CITY OF ALBUQUERQUE

Re: Pulte @ Mirehaven Phase 2A
Request Pad Certification for lots 7-11 & 16 – Not Accepted
Engineer's Stamp dated: 3-11-16 (H09D017F)
Certification dated: 3-31-17

Based on the Certification received 3/31/17, the above referenced cannot be accepted for building permit by Hydrology.

DESIGN REVIEW COMMITTEE	CITY ENGINEER APPROVAL	LAST DESIGN UPDATE	MO./DAY/YR.	MO./DAY/YR.
PROJECT NO.		ZONE MAP NO.	SHEET 3 OF 7

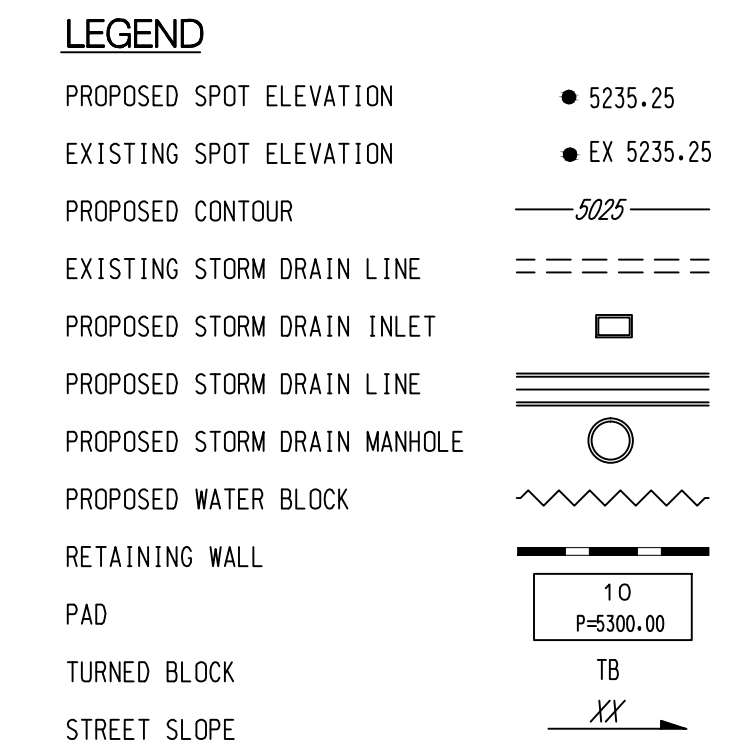
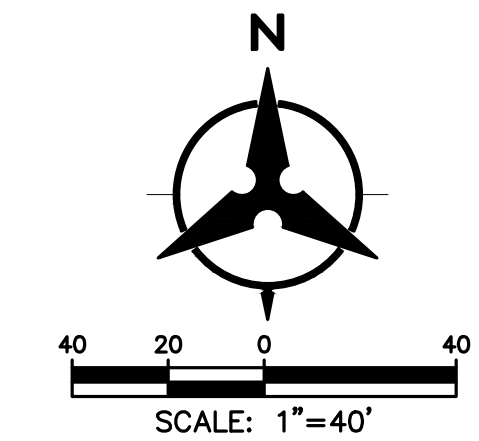
- The swale behind lots 7-11 is incomplete.
- The grade around the pond outlet needs to be lowered, at least 2' below the grate with a local depression.
- The construction debris in the pond needs to be removed.
